**EL PASO COUNTY PLANNING AND
 COMMUNITY DEVELOPMENT
 DEPARTMENT**

GRADING AND EROSION CONTROL PLAN CHECKLIST

STOCK PILE - MIDTOWN COLLECTION AT HANNAH RIDGE FILING NO. 3 (CDR-20-11)

CDR-20-11

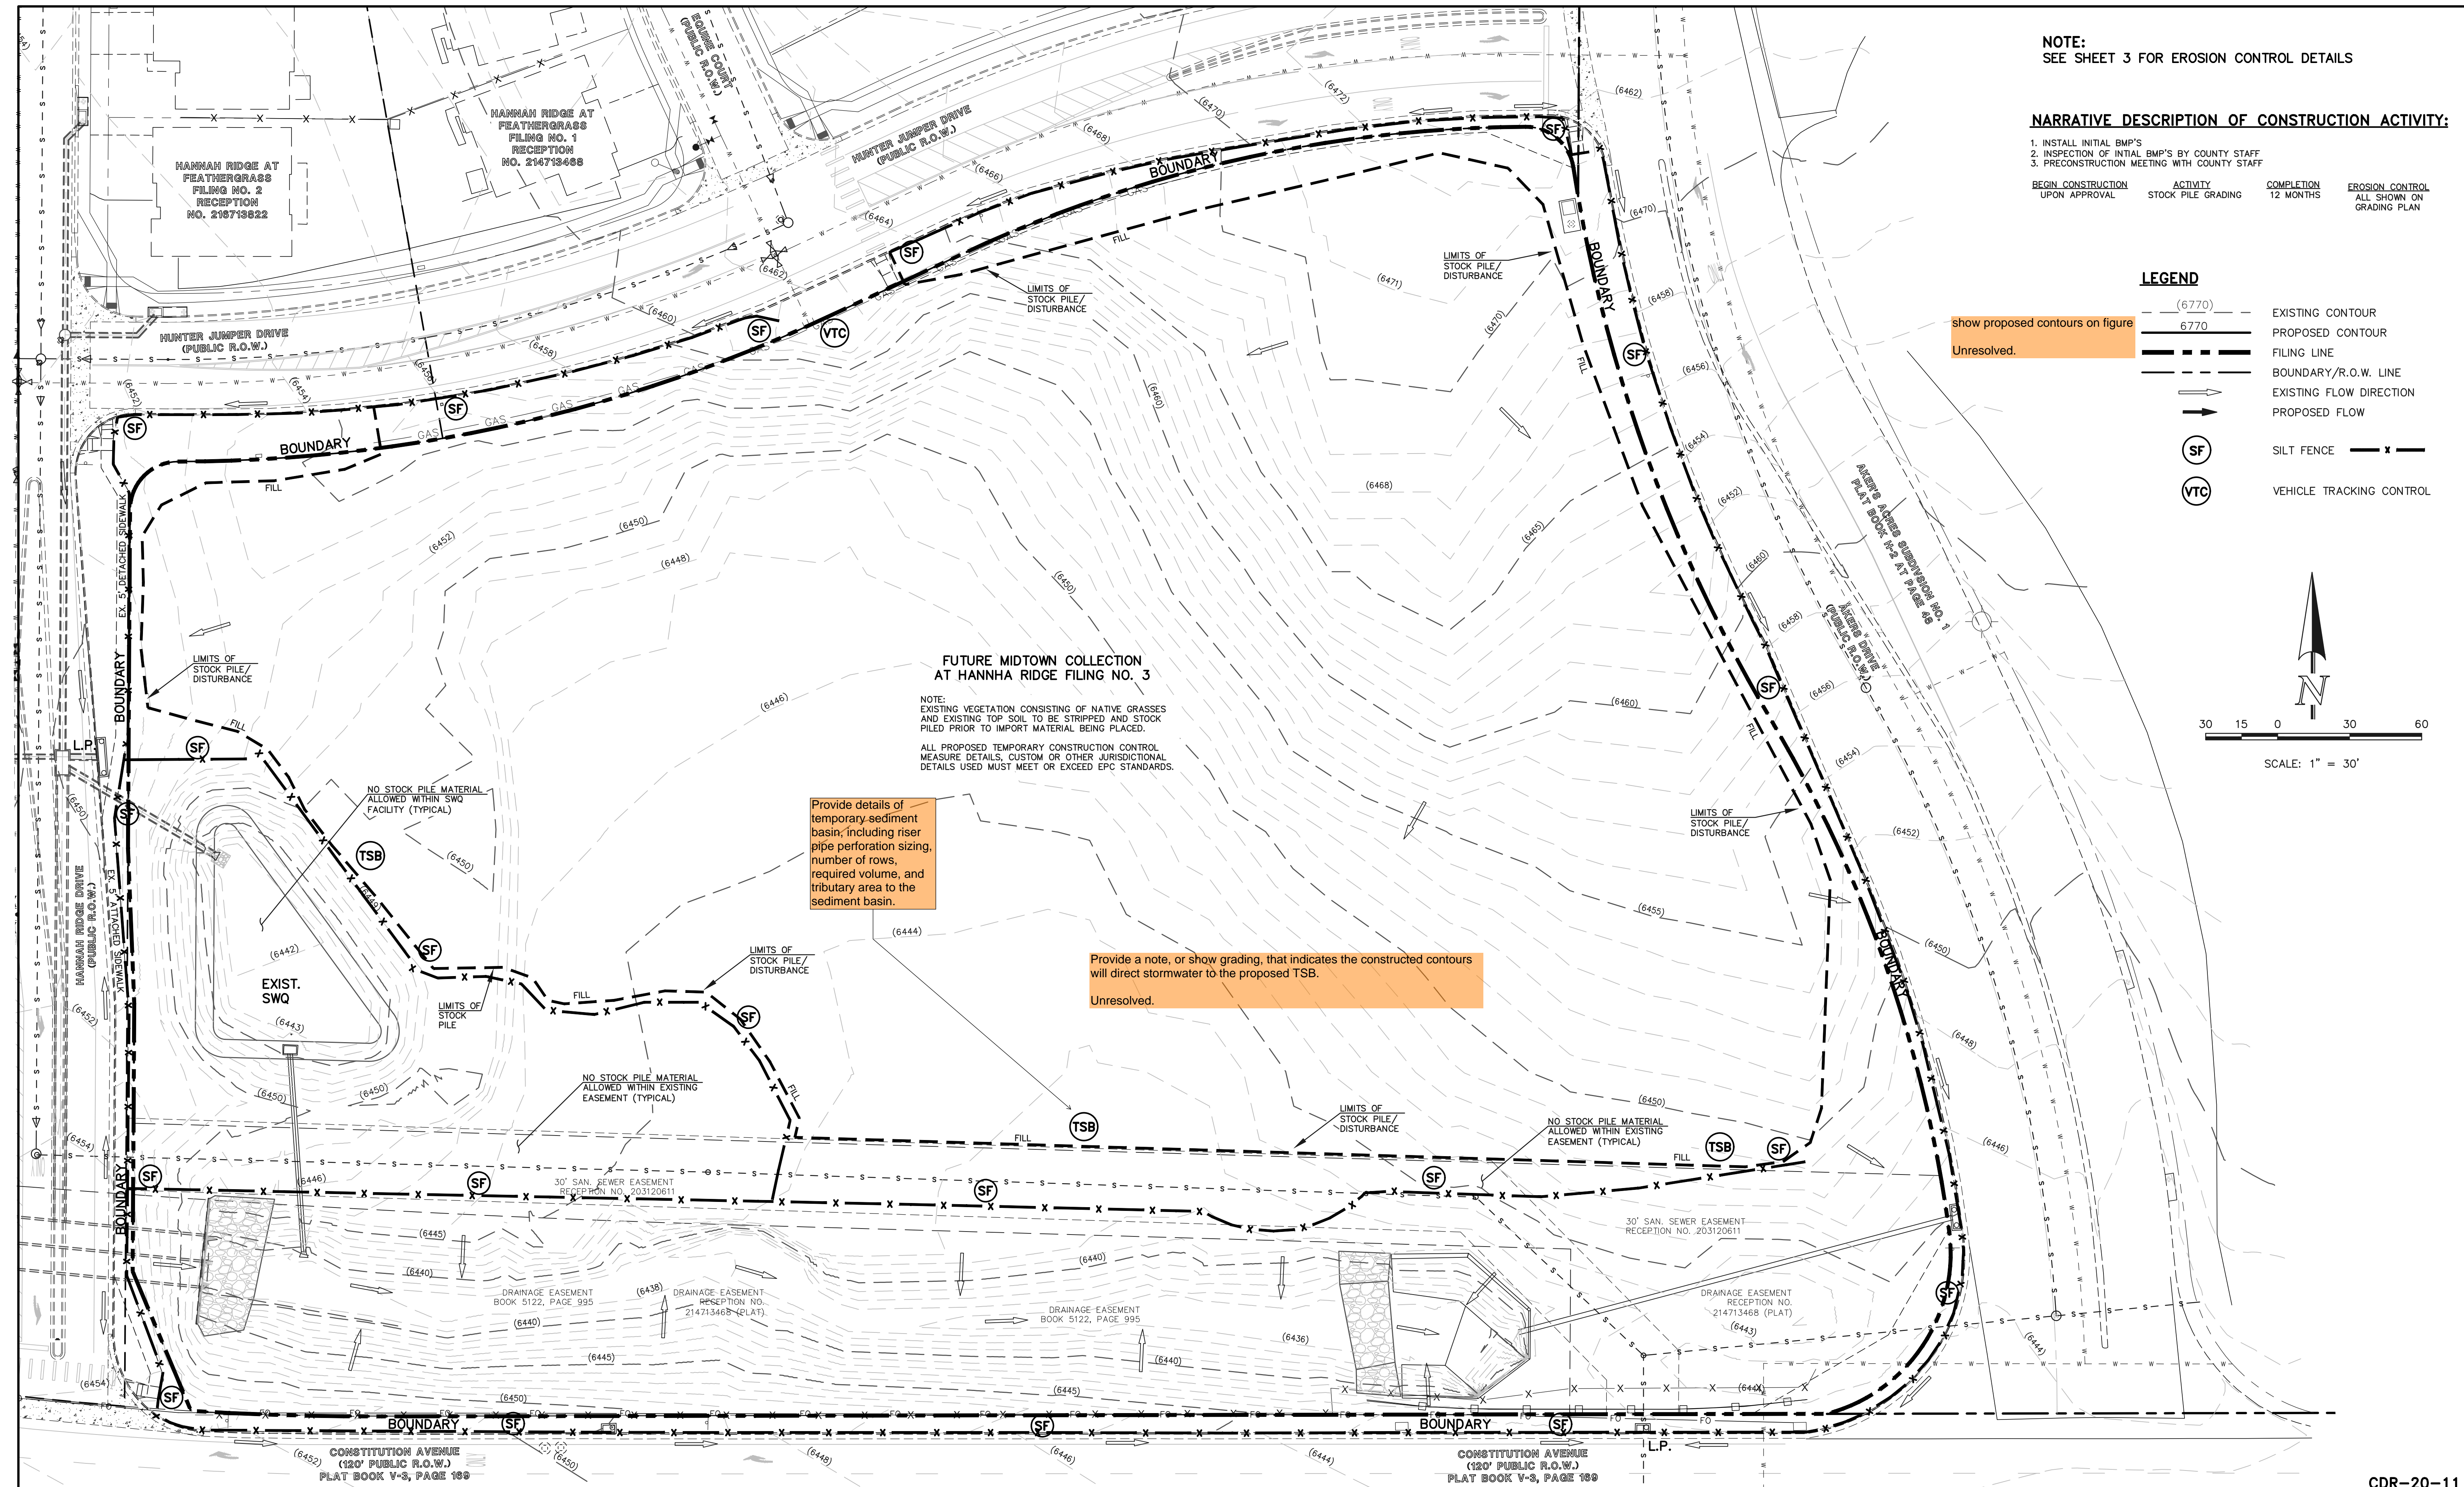
l	Existing and proposed contours 2 feet or less (except for hillside). show proposed contours	X	X
m	Limits of disturbance delineating all anticipated areas of soil disturbance.	X	✓
n	Identify and protect areas outside of the construction site boundary with existing fencing, construction fencing or other methods as appropriate.	X	N/A
o	Offsite grading clearly shown and called out.	X	N/A
p	Areas of cut and fill identified.	X	✓
q	Conclusions from soils/geotechnical report and geologic hazards report incorporated in grading design (slopes, embankments, materials, mitigation, etc.)	X	✓
r	Proposed slopes steeper than 3:1 with top and toe of slope delineated. Erosion control blanketing or other protective covering required.	X	N/A
s	Stormwater flow direction arrows.	X	✓
t	Location of any dedicated asphalt / concrete batch plants.		N/A
u	Areas used for staging, storage of building materials, soils (stockpiles) or wastes. The use of construction office trailers requires PCD permitting.	X	✓

Provide details of temporary sediment basin, including riser pipe perforation sizing, number of rows, required volume, and tributary area to the sediment basin.
